CHENNAI METROPOLITAN DEVELOPMENT AUTHORITY
 Thalamuthu Natarajan Building, No.1, Gandhi Irwin Road, Egmore,
 Chennai - 600 008
 Phone : 28414855 Fax: 91-044-28548416
 E-mail: mcmda@tn.gov.in, Web site: www.cmdachennai.gov.in

Letter No.PP/NHRB/N/873/2019, Dated: 22.11.2019

Sub: CMDA – Area Plans Unit - ‘B’ Channel (North) - Planning Permission Application for the proposed construction of Stilt Floors + 3 floors 2 Dwelling Units at Plot No.7, New Door No.6, State bank of India Officers’ Colony, 1st street Perambur Barracks, Chennai-12. R.S.No. 264,264/19, Block No. 16, of Perambur village – Remittance of DC & Other charges – DC advice Sent – Reg.

SITE CUM STILT FLOOR PLAN

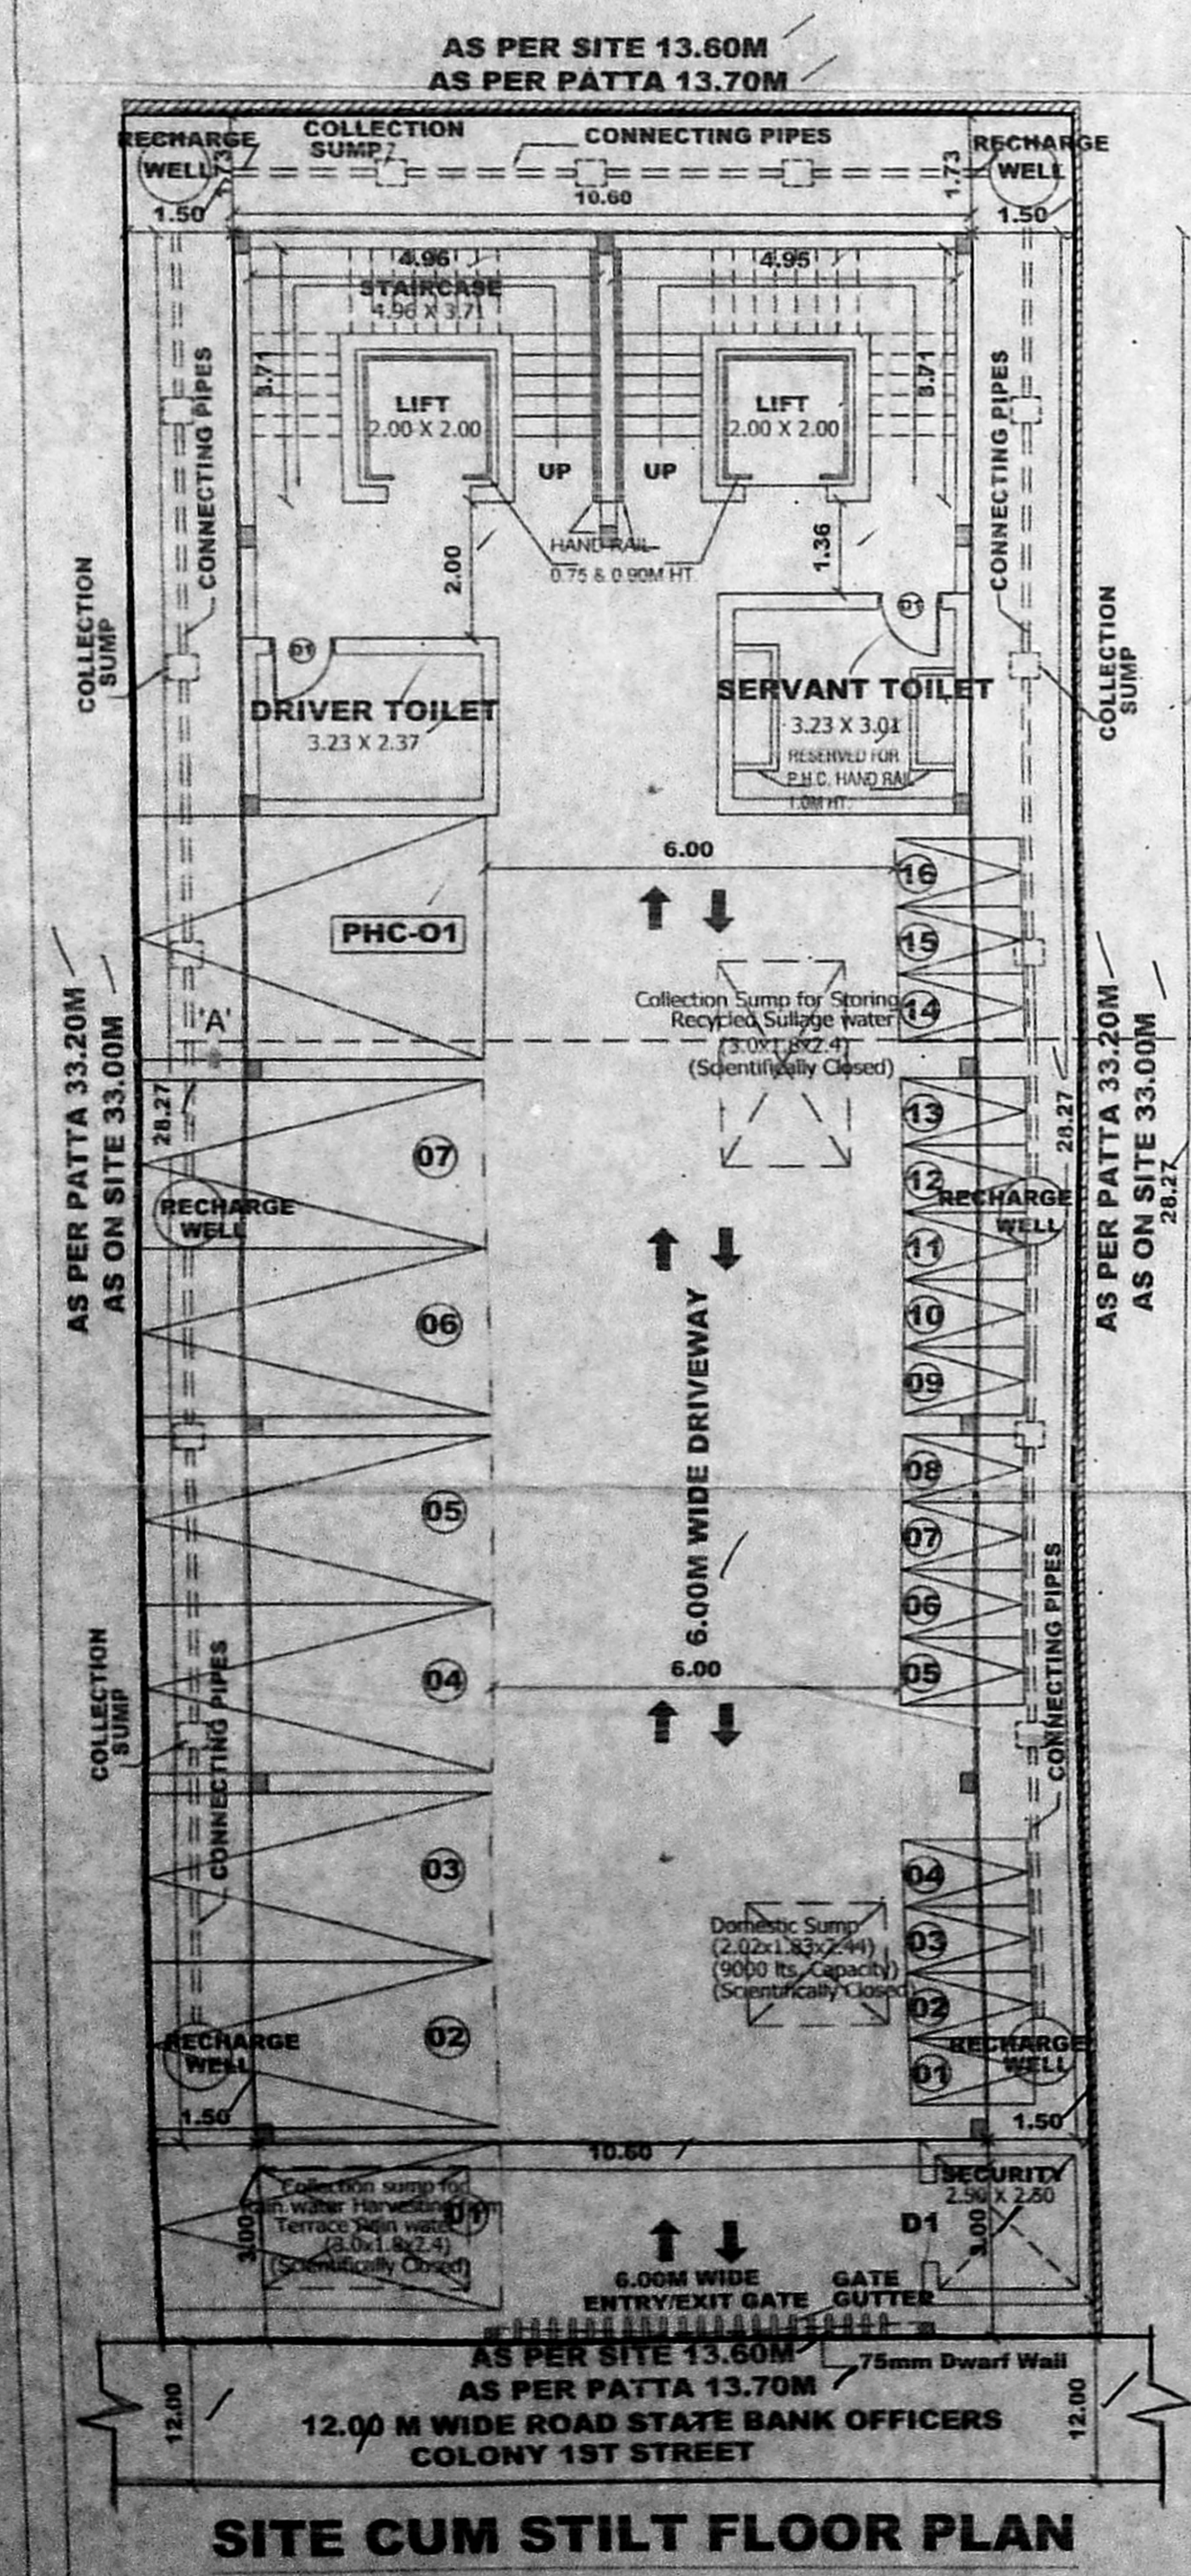
5. This demand notice (DC advice) pertaining to the proposed construction falls within the jurisdiction of The commissioner, Corporation of Chennai, Chennai
6. You are requested to furnish the following particulars and 5 copies of revised plan rectifying the following corrections:
1. Site plan is to be drawn showing dimensions both as per Patta and as on site conditions and distinguishing the difference by hatching and indicating the setbacks from least boundary line.
 2. Rain water harvesting to be shown as per CBR 35(5) Annexure XXII drawing.
 3. Rear side of the Patta to be signed by Deputy Tahsildar.
 4. Area statement needs correction.
 5. Copy of the 2nd Floor Residential unit is to be drawn clearly as a Dwelling unit with respect to Toilet provisions and arrangement.

FIRST FLOOR PLAN

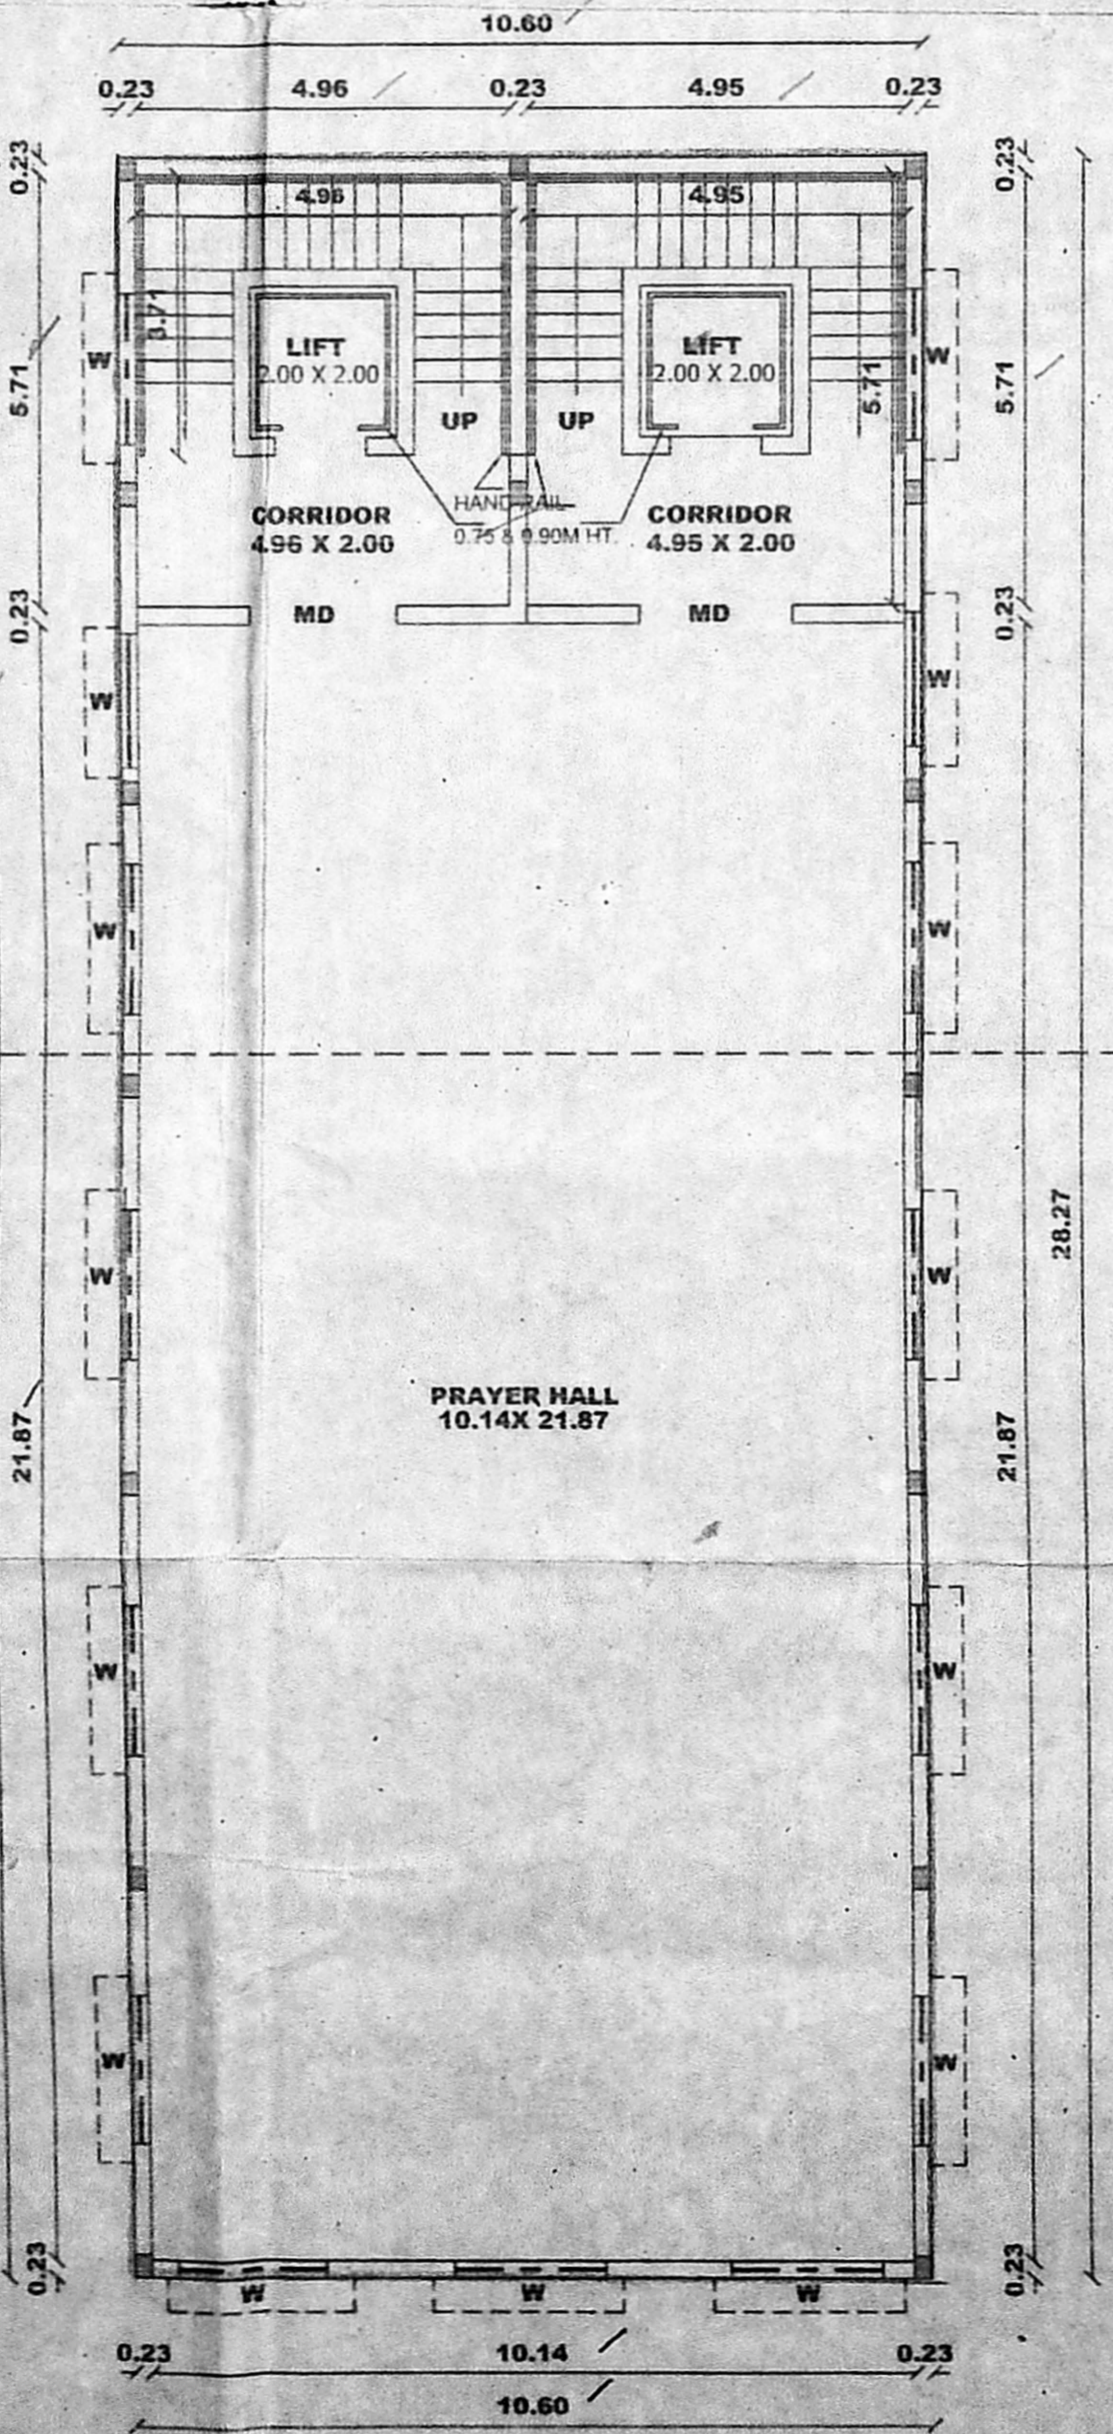
The Staircase at FF to be removed as one staircase is enough for Residential area in FF and 2nd Floor.
